**Consultation Response from KC,
Highways Development Management**

2024/91522 50, Rosewood Drive, Shaw Cross, Dewsbury, WF12 7SX

Erection of detached garage and alterations to integral garage to increase living accommodation

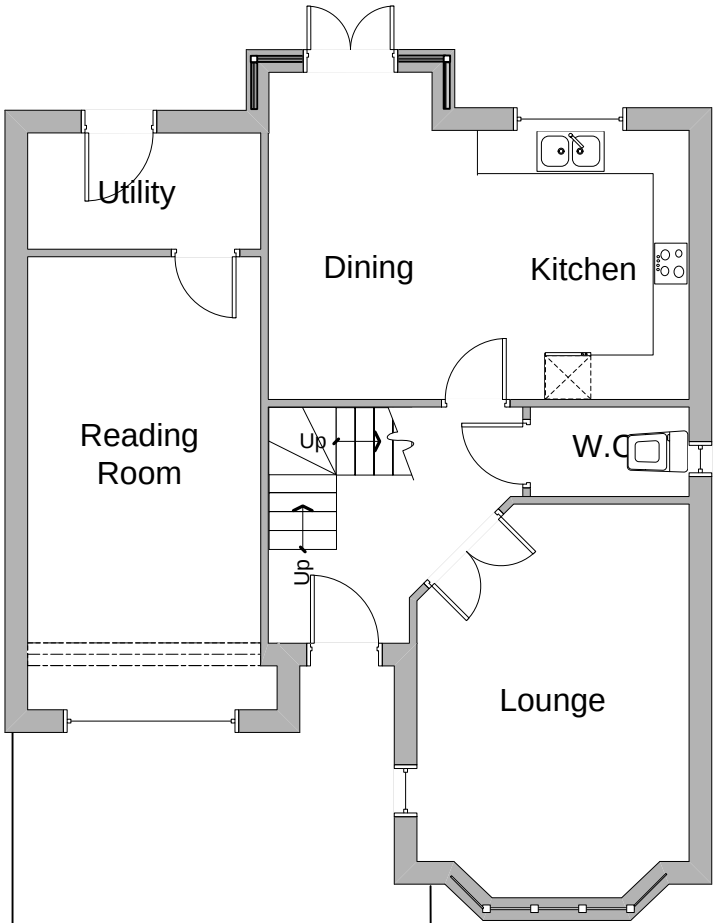
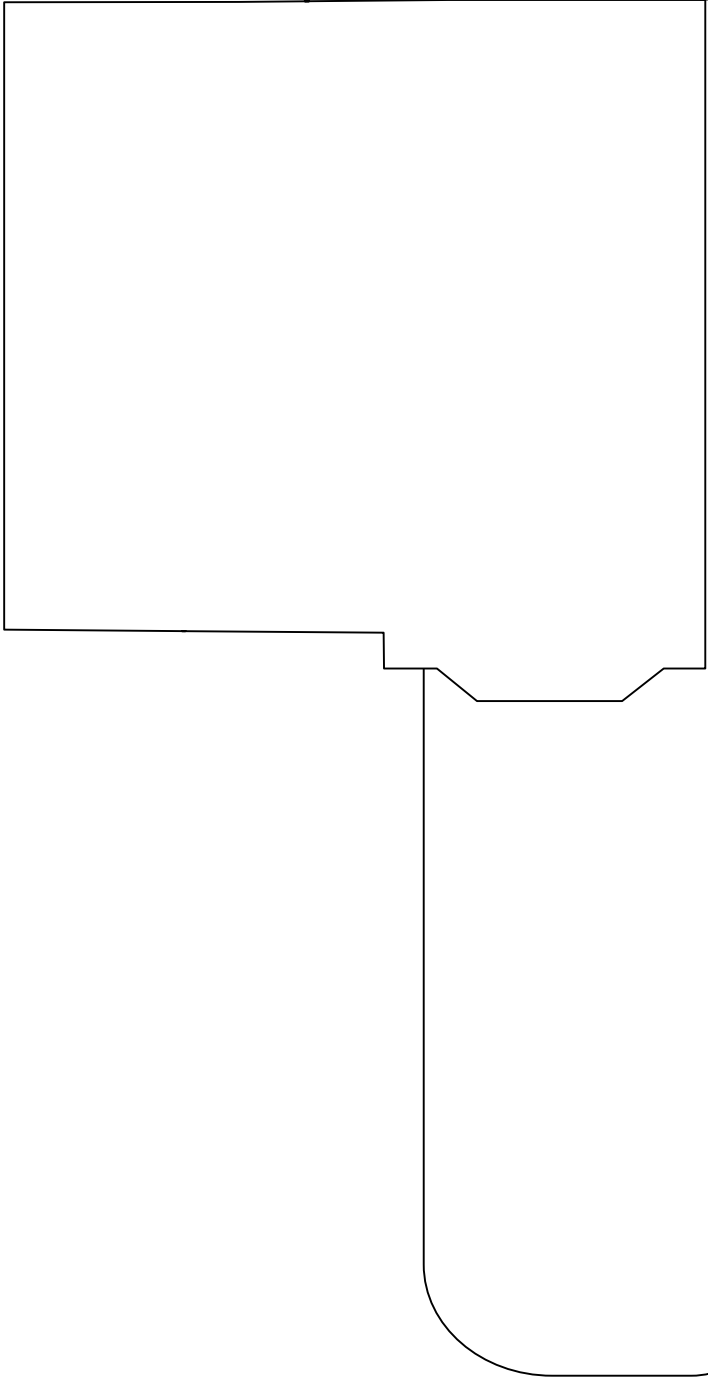
The location of the proposed garage removes turning space to the driveway.

To be considered acceptable to Highways Development Management to applicants should demonstrate that independent internal vehicle turning is retained to the driveway. The length of the proposed garage should also be increased.

Proposed Garage

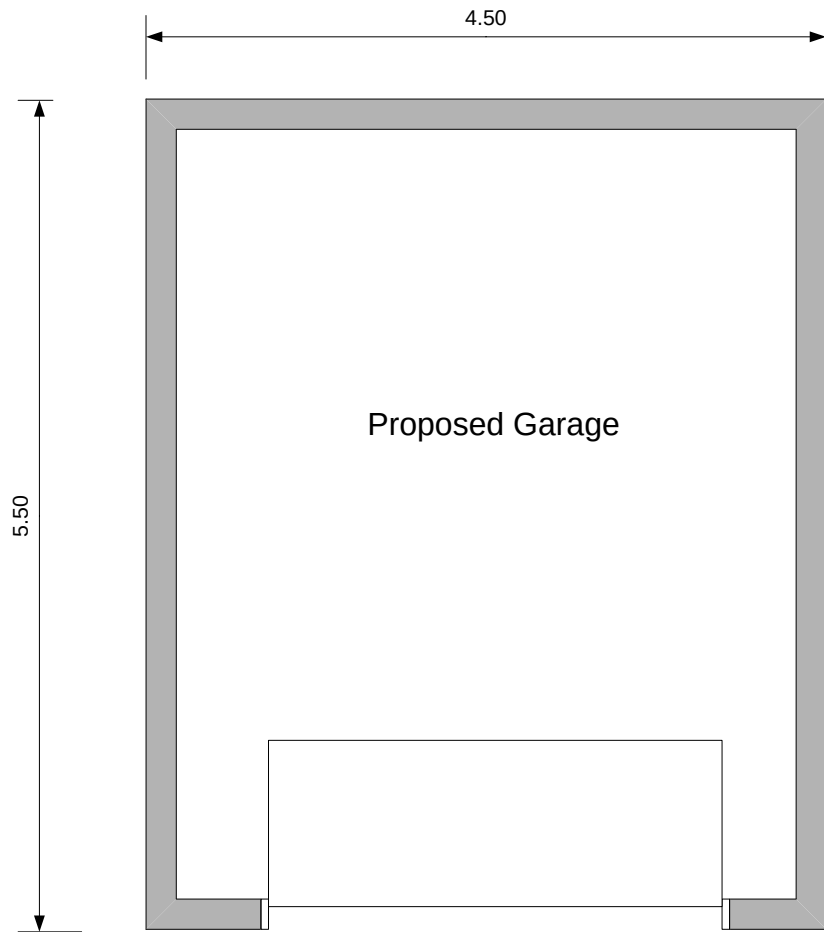
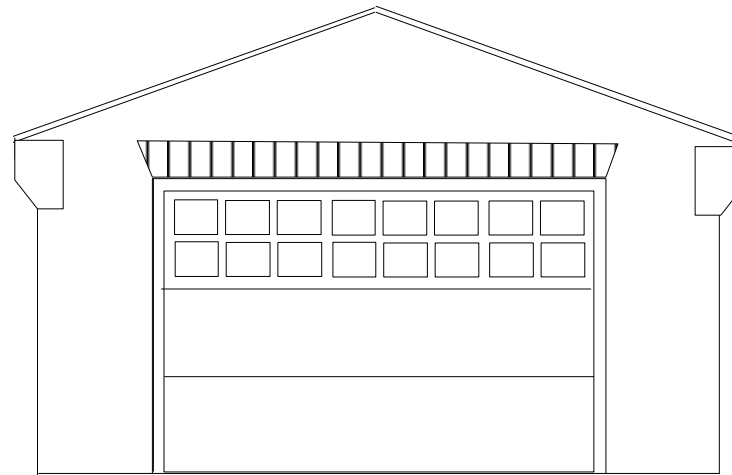
The internal length of the proposed garage is approximately 4.6m which is not considered sufficient to be a parking space. An internal length of 5.0m is recommended.
